Re.: Planning Ref. M/13/15/HH for Summerhouse and Pergola
4 Sea Way, Middleton-on-Sea.

I am writing to object to the above referenced Planning Application.

SITE PLAN - 1/500

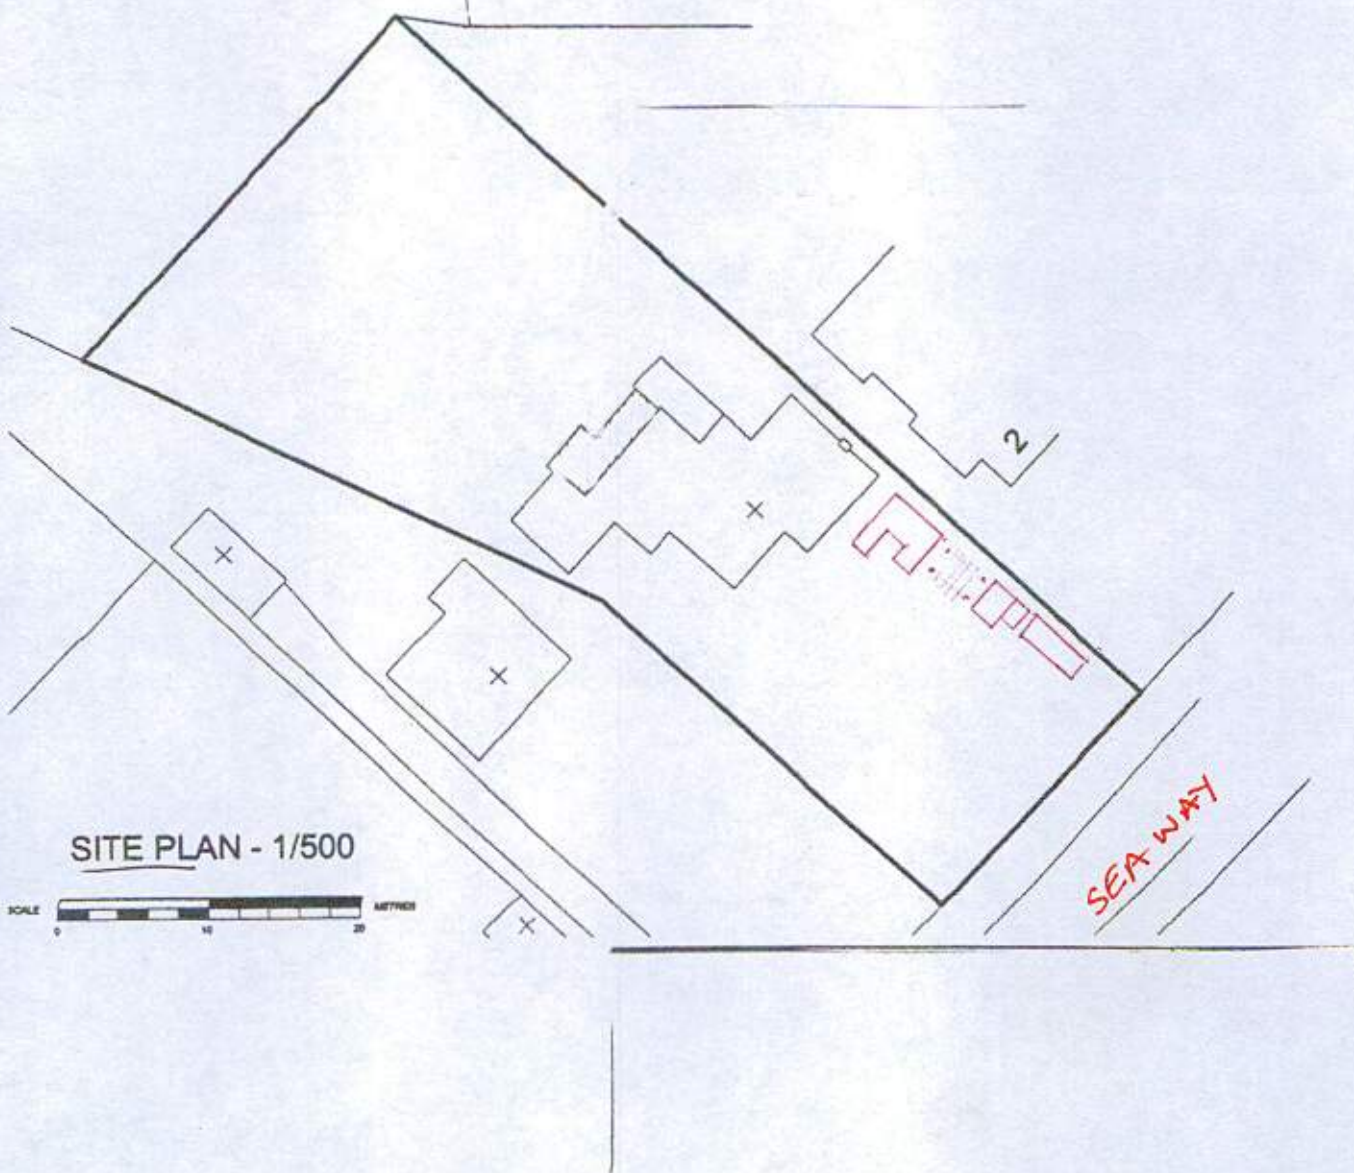
This summerhouse is in front of the building line and is obtrusive to the street scene, and does not comply with the Village Design Statement. If this were to be allowed, this would herald in a complete and irrevocable change to the street scene, not only on this road but everywhere. The front building line of street scenes is of fundamental importance.
